December 18, 2018

**Subject: Response to Technical Circulation Comments**

Please find the following comments in response to the comments that were provided by you by November 8<sup>th</sup>, 2018 pertaining to the Site Plan Application for 5471 Boundary Road (Capital Region Resource Recovery Centre):

| PROJECT NO. | CONTROL | REV. | of | DRAWING |
|-------------|---------|------|----|---------|
| 1787048 | 0007 | 2 | | SS1 |

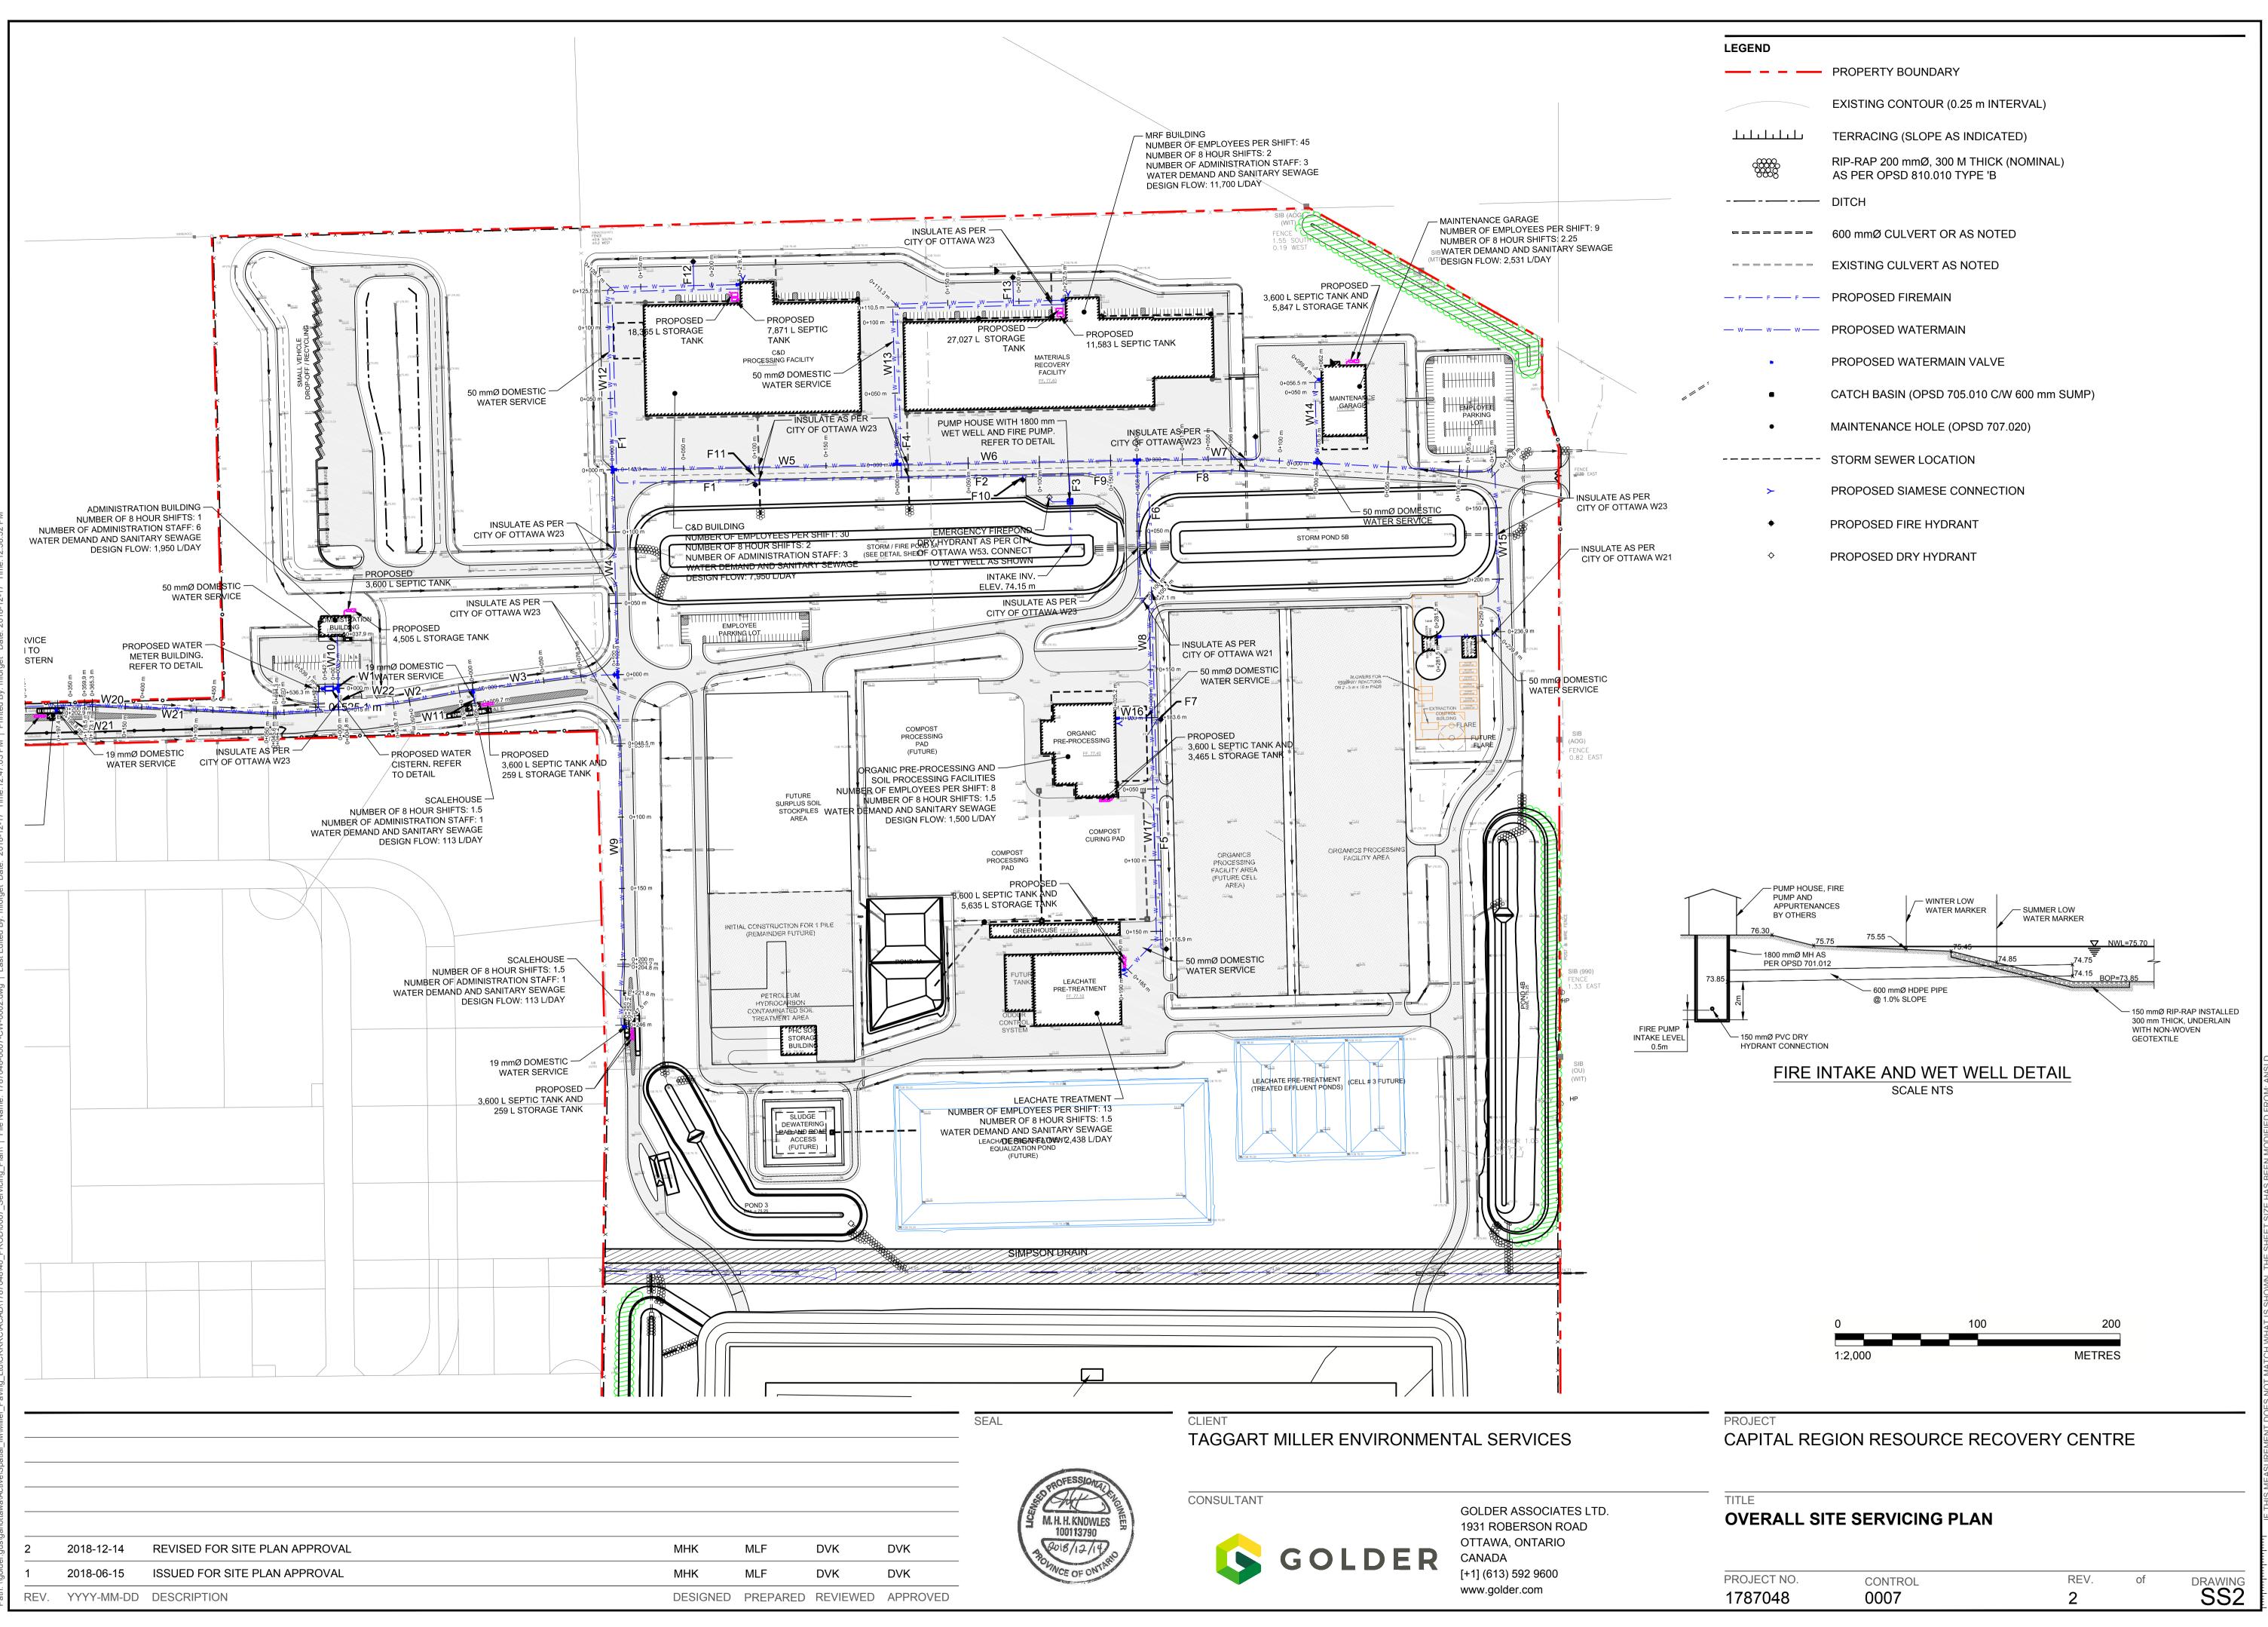
<b>Servicing Plan</b>	
52	Storm Sewers are not labeled on the servicing plans.	These have been labelled.
53	Pipe materials for the fire watermain needs to be labeled	Labels are included on Drawing SS1.
54	C17 Arrow pointing to fire hydrant. No symbol shown on plan.	This has been updated.
55	What is the hatching over the Electrical and Fiber optic lines?	The solid coloring is concrete duct bank and the hatched diagonal lines area patio slabs over the buried line.
56	What is the watermain material on site? Not labeled.	The watermain material is included on Drawing SS1.
57	No fire protection for the Administration building?	Fire protection is not required as the building is less than 600 m2. This has been confirmed with Fire Services.
58	I think there should be valves at every junction of the watermain on site	These have been added.
59	C22 Water service provided to the secondary digester building. There are no toilets or sinks proposed. Why 50mm diameter pipe? This may add to your water age issues.	The secondary digester includes a water service for washdown but no potable use. The service has been reduced to 25 mm diameter.
